**CIMARRON HILLS PHASE 2 MULTI-FAMILY  
SITE DEVELOPMENT PLAN AND FINAL PLAT LETTER OF INTENT**

On behalf of Jackson Dearborn Partners, request approval of the Site Development Plan (SDP) for Tract A to be re-platted as Lot 2 (Phase 2) and the approval of a 108-unit Multifamily development.

Approval of 7.680-acre the 'Cimarron Hills-Phase 2 Site Development Plan (hereafter, "Plan")', Tract A of approved Solace of Colorado Springs Final Plat (Document No. 221714877) in the RM-12 Zone. **PHASE 1-FILE NO. 2032**

Land Use

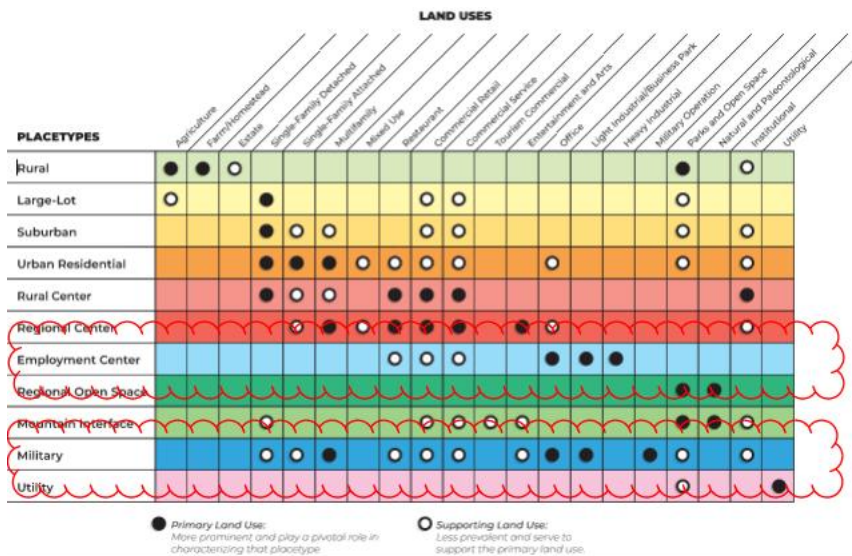
This is an Employment Center placetype. Residential uses are not recommended in employment centers - the zoning is nonconforming to the placetype.

This is not correct. The property is not within the military placetype. It is within the military reservation buffer, so the military placetype can influence the development of the property. Important to make this distinction - you can use the military placetype to help justify, but be clear that it is not located within it.

The Your El Paso Master Plan locates this property within a Military placetype where higher density and multifamily residential uses are identified as a primary land use in this area designation.

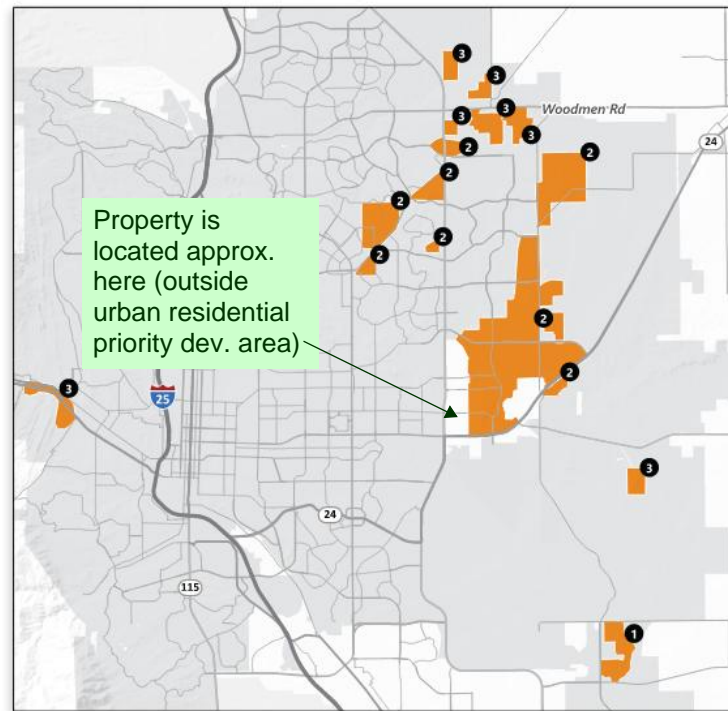
According to the Priority Development Areas Map in the Master Plan, the site is located within an Urban Residential Priority Development Area where “new residential development should be prioritized first for new residential development to accommodate growth” in the County.

This is not correct. This property is located within an Employment Center priority development area, which this development is not consistent with.

Replace this section with an analysis of the employment center priority area that this property is located in.
